SUBJECT: P/140/16/OUT - Outline application for access only - mixed use development comprising of up to 400 dwellings, a care home with up to 70 beds, a Local Centre comprising up to 2000sqm of A1/A2/A3/D1/sui generis floorspace, provision of land for a 1FE primary school (with sufficient space to ensure that it is expandable to 2FE), provision of land for a scout hut, safeguarding of land to help link the site to the Pagham Harbour Cycle Route & other community uses including public open space & allotments with some matters reserved. This application is a departure from the Development plan

Land South of Summer Lane & West of, Pagham Road, Pagham, West Sussex

West Sussex County Council Public Rights of Way would like to comment on this application as there are Rights of Way which will be impacted by this proposal.

Figure 5.4 – Link to Pagham Harbour cycle route

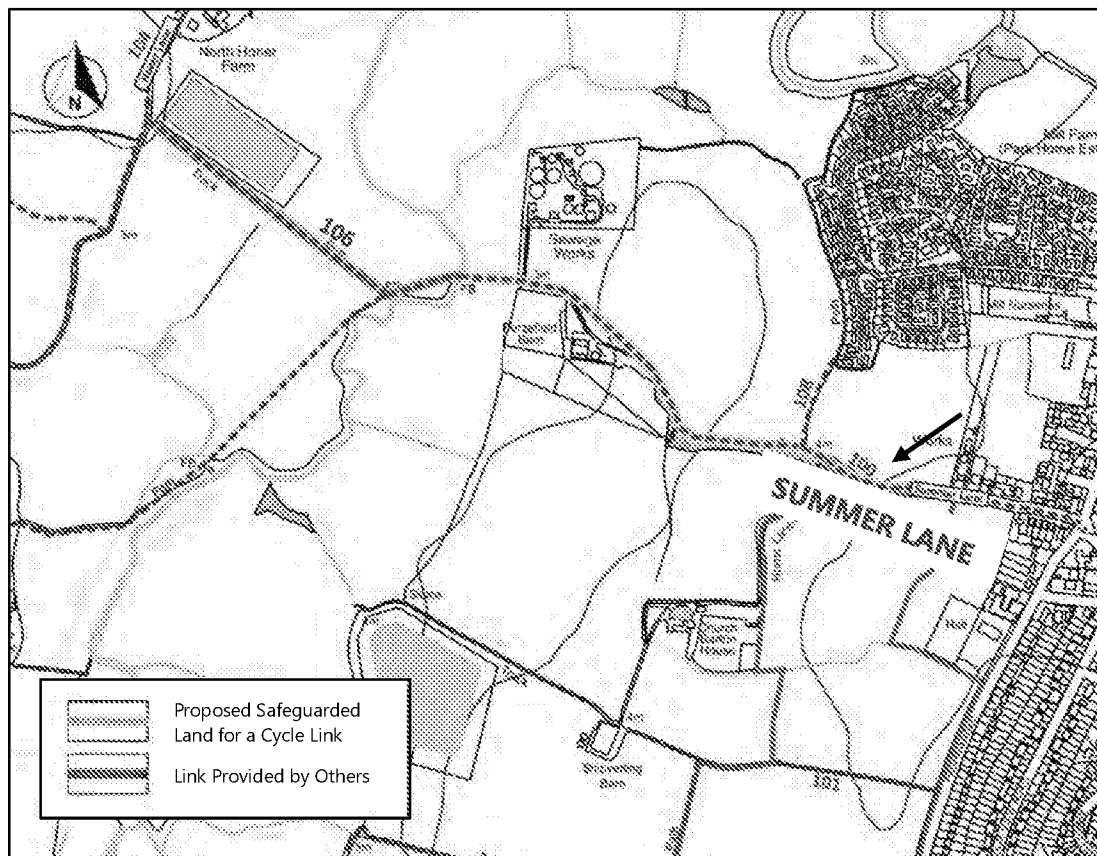
1. With respects to cycling towards Chichester, there is a longstanding WSCC aspiration to secure a route from Pagham to Chichester via Sidlesham. Such a link would then achieve a route using lightly trafficked roads or off-road tracks. This route proposed would use existing public rights of way nos. 100, 104, and 106. These are all public footpaths at present and their legal status would need to be changed to bridleway to allow cycling. The surfacing on parts of the route would also need to be improved along with a minor modification to the existing bridleway standard bridge over the Pagham Rife to accommodate both cyclists and equestrians. This would greatly benefit the local community and new residents for both leisure and commuting.

2. The development proposes to safeguard an element of the proposed cycleway/bridleway link. This length falls within land under the control of the applicant. Whilst the completion of the link would then require works that appear to lay outside the control of the applicant, it would still be desirable for the applicant to use all reasonable endeavours to secure upgrading of the whole route. In the event, that the applicant cannot achieve the necessary landowner consents to undertake works; a contribution should be made to WSCC to allow them to pursue the delivery of this route.
